# CITY OF ALBUQUERQUE

June 13, 2018

Scott Ashcraft, Las Ventanas NM, Inc., scottashcraft@comcast.net  
Site: Bishops Compound

**Re: Drainage Ordinance (14-5-2-1) Violations for Erosion and Sediment Control**

#### Erosion Sediment Control Plan

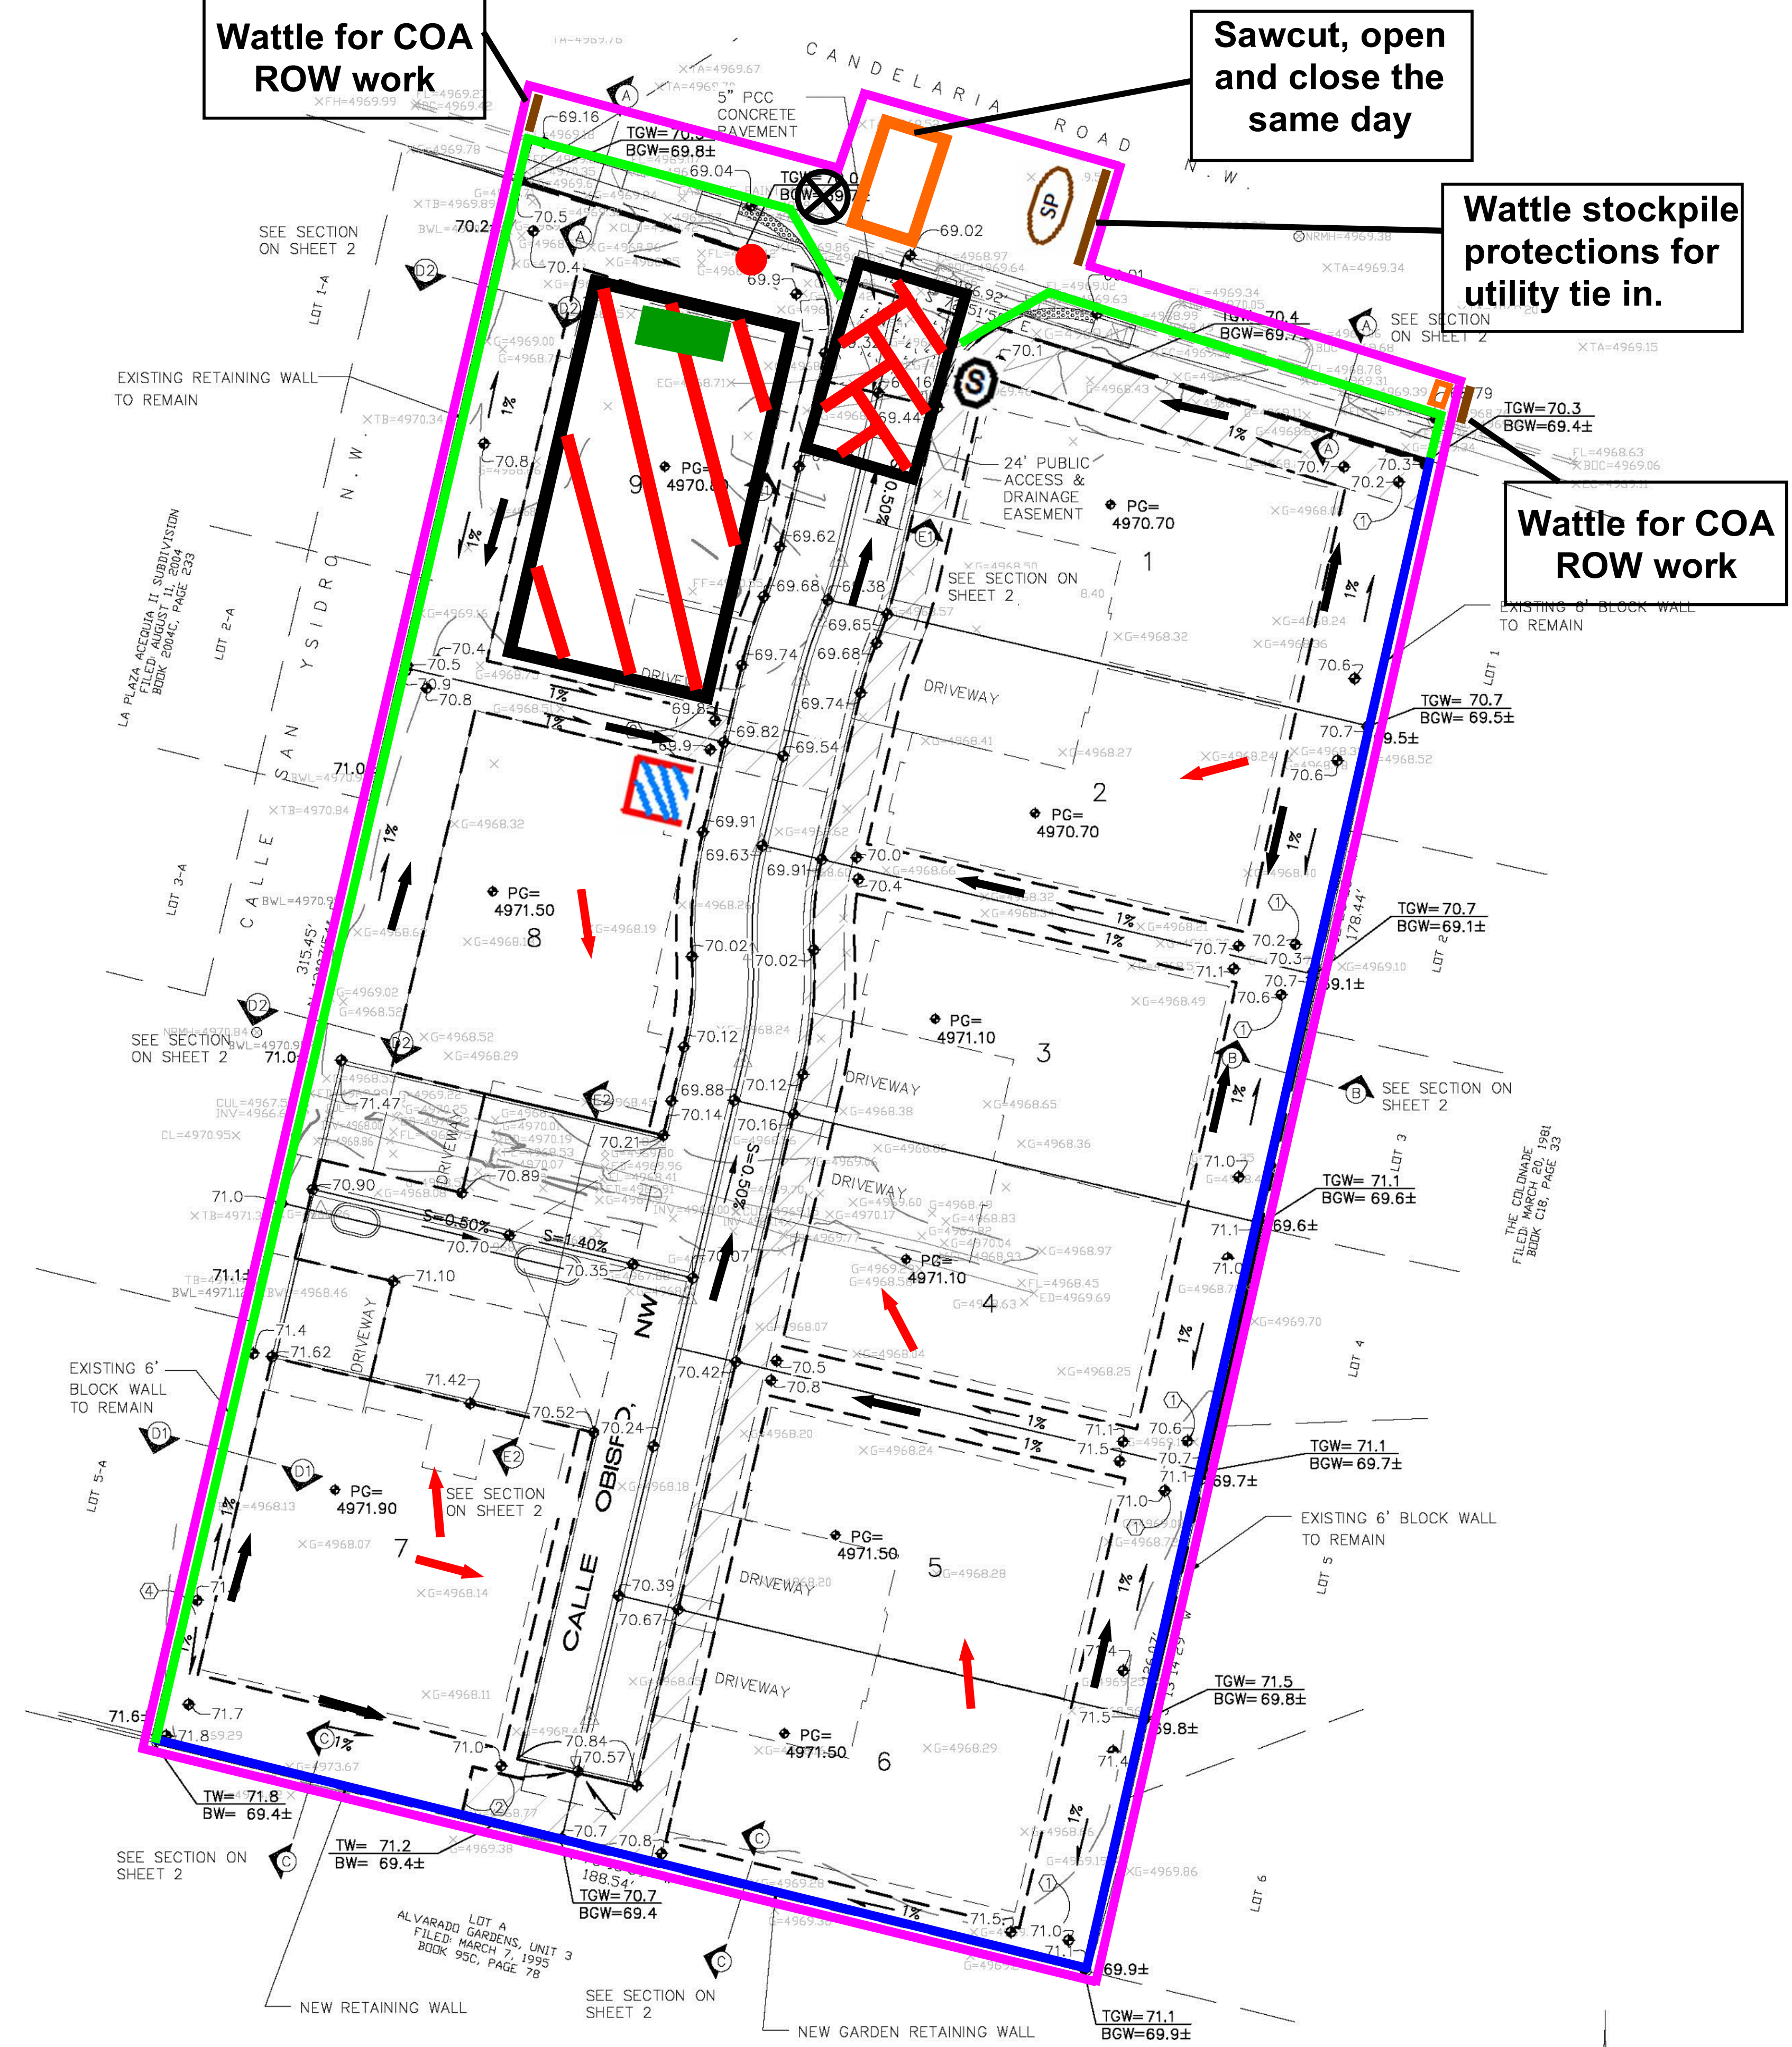
1. There were no sediment BMPs on lots under construction.
2. Wash-out on one of the lots.
3. There was sediment in Calle Obispo Lane.

No sediment BMP and sediment in the street.

No sediment BMP.

Wash-out on a lot.

1. Install a sediment BMP (cutback/ mulch sock/wattle) on lots under construction.
2. Remove the wash-out from one of the lots and prevent this from occurring in the future.
3. Remove the sediment from Calle Obispo Lane.
